Our Ref: LM/ARU/20/25A

Date 2nd September 2020

RE: Land to the south of Ford Lane and East of North End Road Yapton BN18 0DS

Thank you for your correspondence of the 26th August 2020, advising me of a planning application for Approval of reserved matters following outline consent Y/80/16/OUT for 4.5ha of residential development comprising of 3.4ha of land for the erection of 100 No. dwellings (up to 30 (30%) affordable housing) together with 1.1ha of land set aside for public open space, strategic landscaping, 2.2ha of public open space, green corridors with vehicular access from Ford Lane & pedestrian/cycle access only from North End Road (resubmission following Y/19/20/RES). This application may affect the setting of listed buildings, affects the character & appearance of the Church Lane, Yapton Conservation Area & affects a Public Right of Way. This site falls within Strategic Site SP2 (Zero Rated) at the above location, for which you seek advice from a crime prevention viewpoint.

Detailed Play Provision - LAP 1

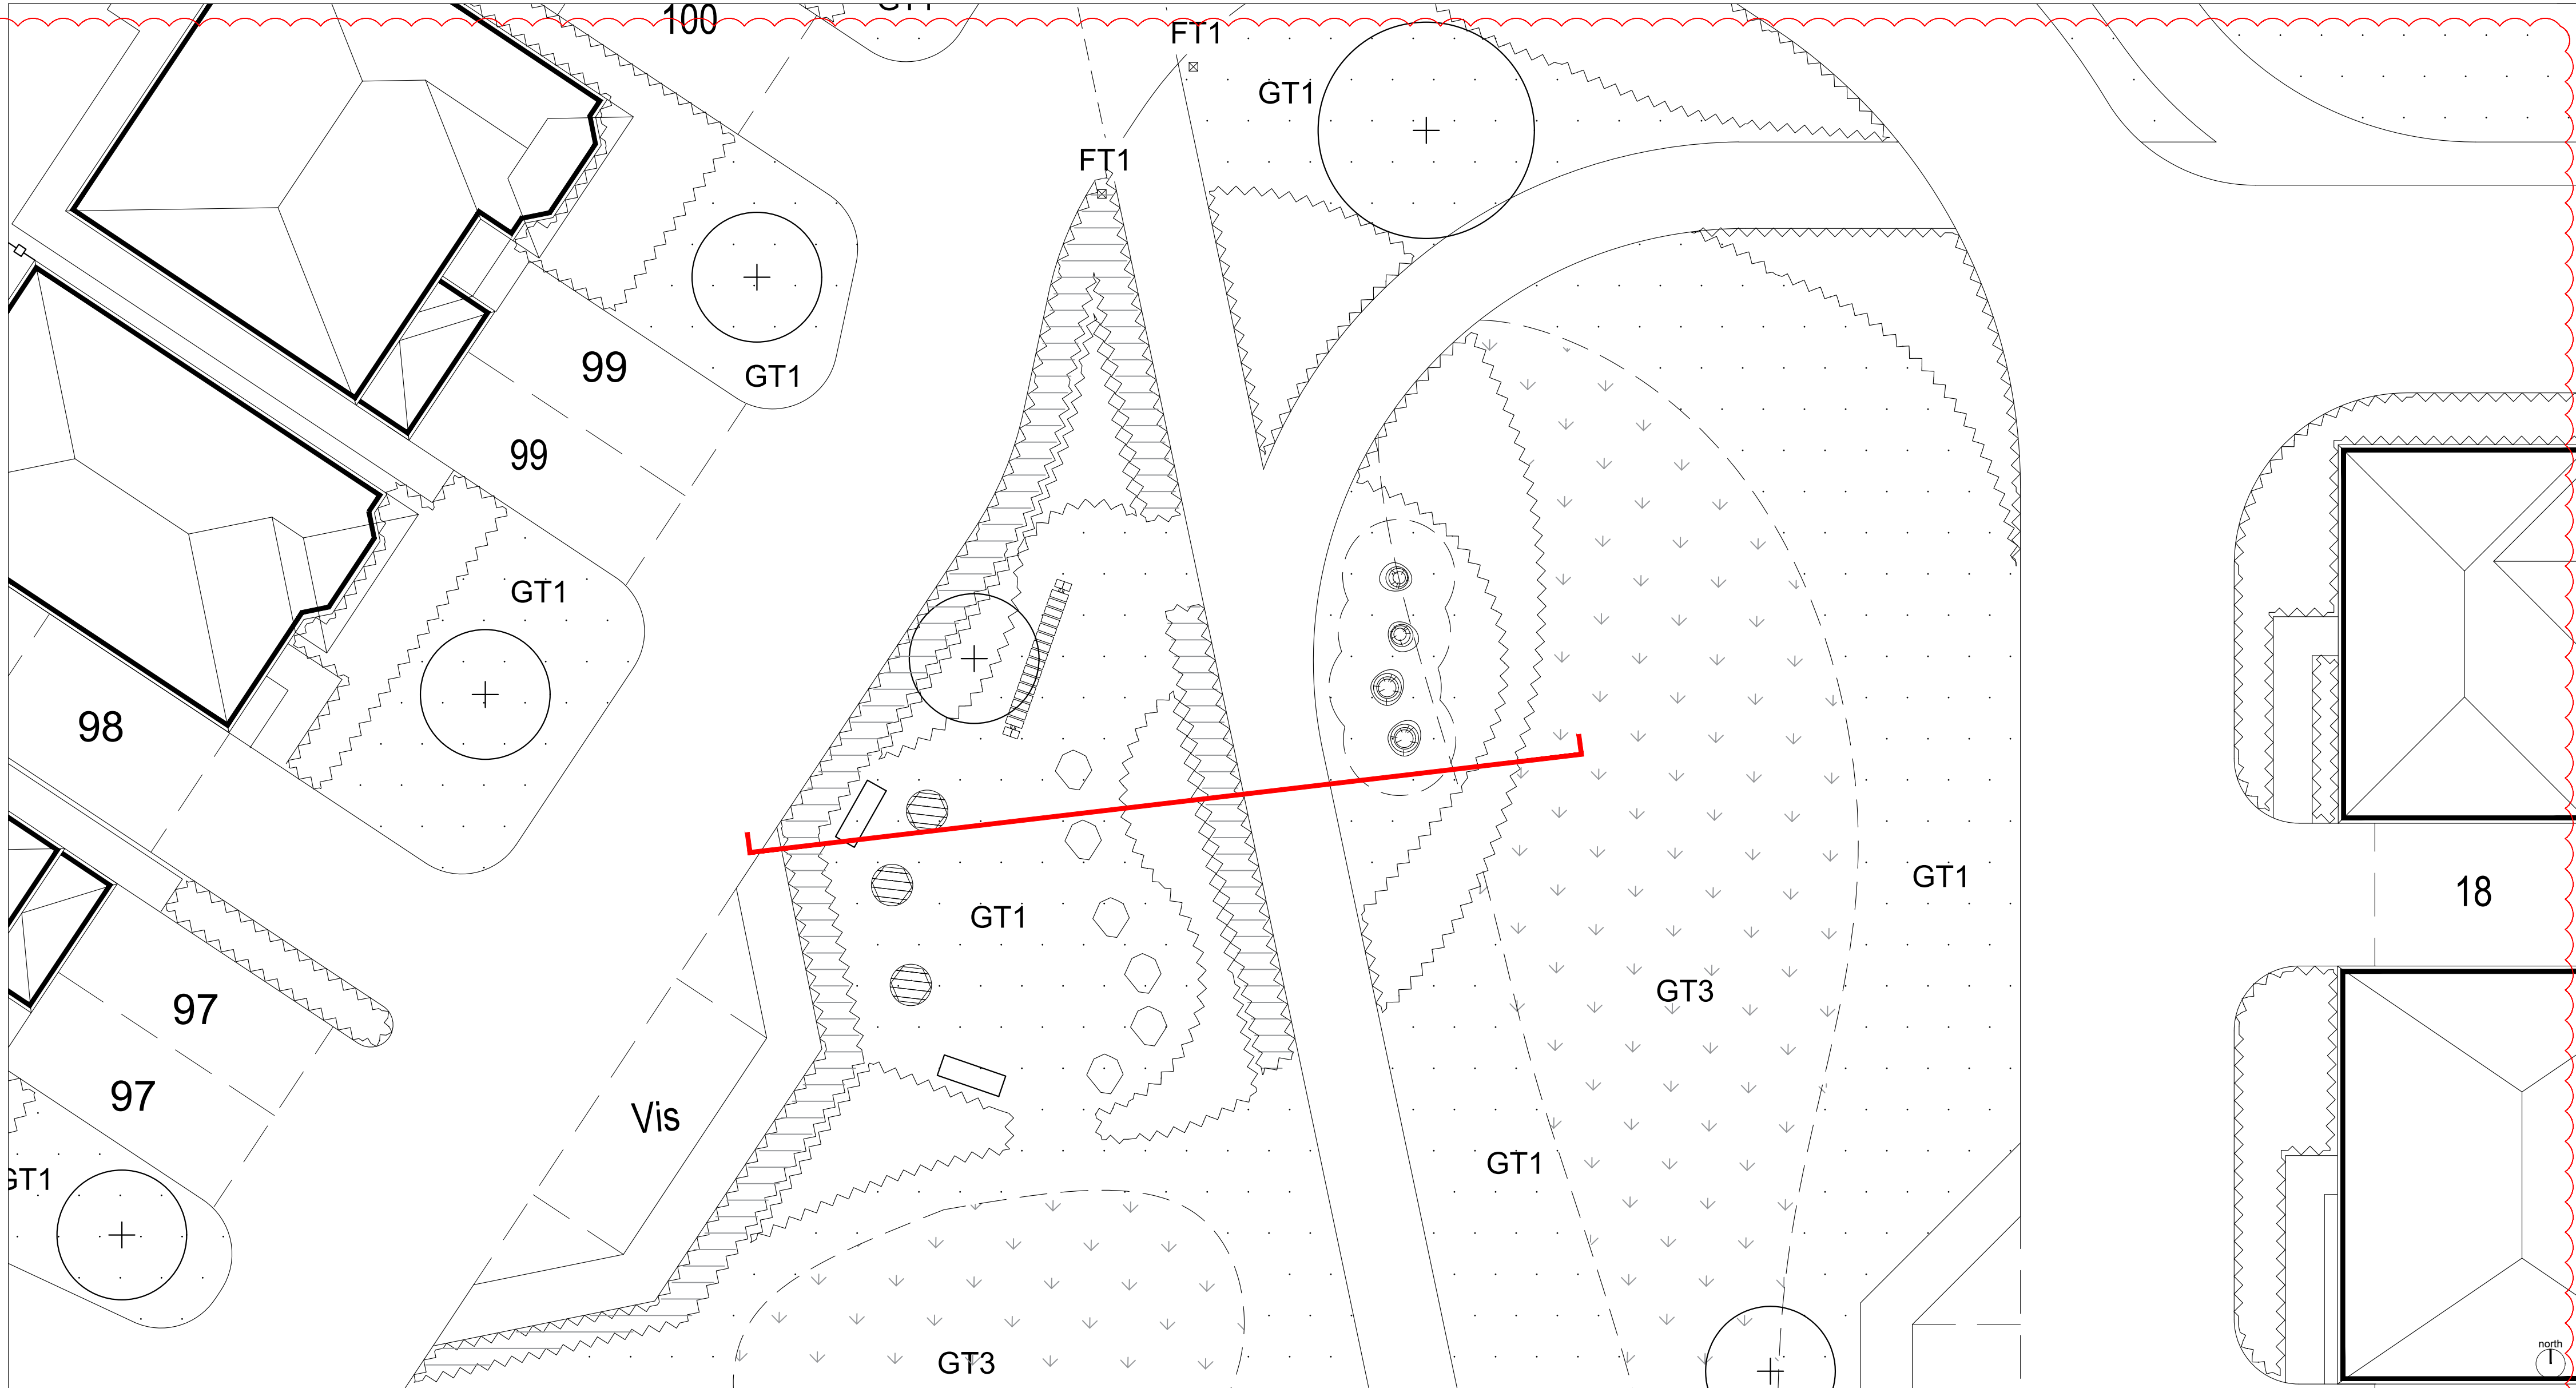
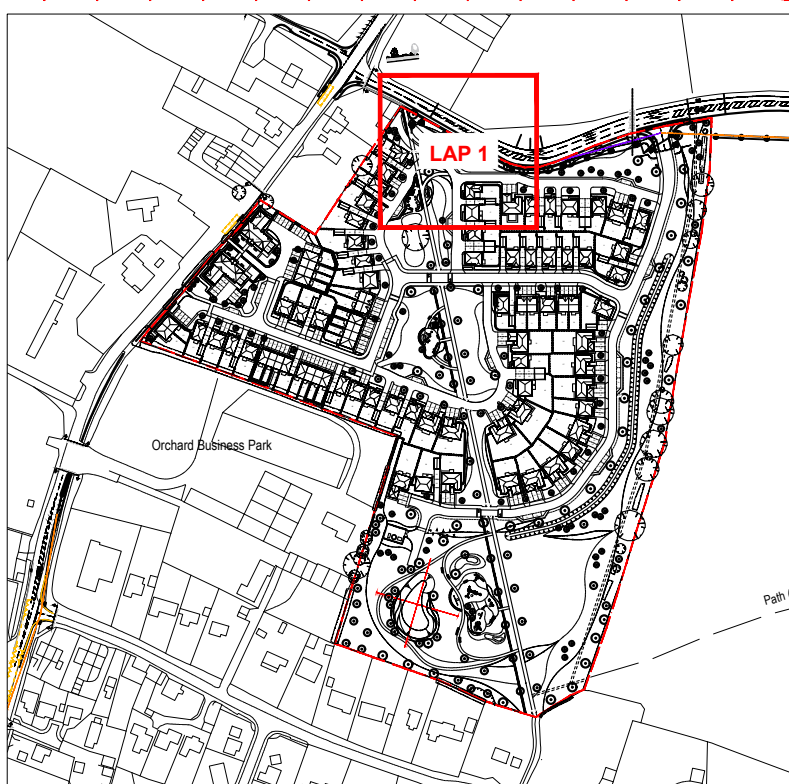
With regards to the LAP - areas of play should be situated in an environment that is stimulating and safe for all children, be overlooked with good natural surveillance to ensure the safety of users and the protection of equipment, which can be vulnerable to misuse. They should be designed to allow natural surveillance from nearby dwellings with safe and accessible routes for users to come and go. Boundaries between public and private space should be clearly defined and open spaces must have features which prevent unauthorised vehicular access. I would ask that when consideration is given to the eventual location that it is surrounded with railings with self-closing gates to provide a dog free environment.

With regards to the proposed landscaping and planting from a crime prevention perspective I ask that ground planting should not be higher than 1 metre with tree canopies no lower than 2 metres.
This arrangement provides a window of observation throughout the area.
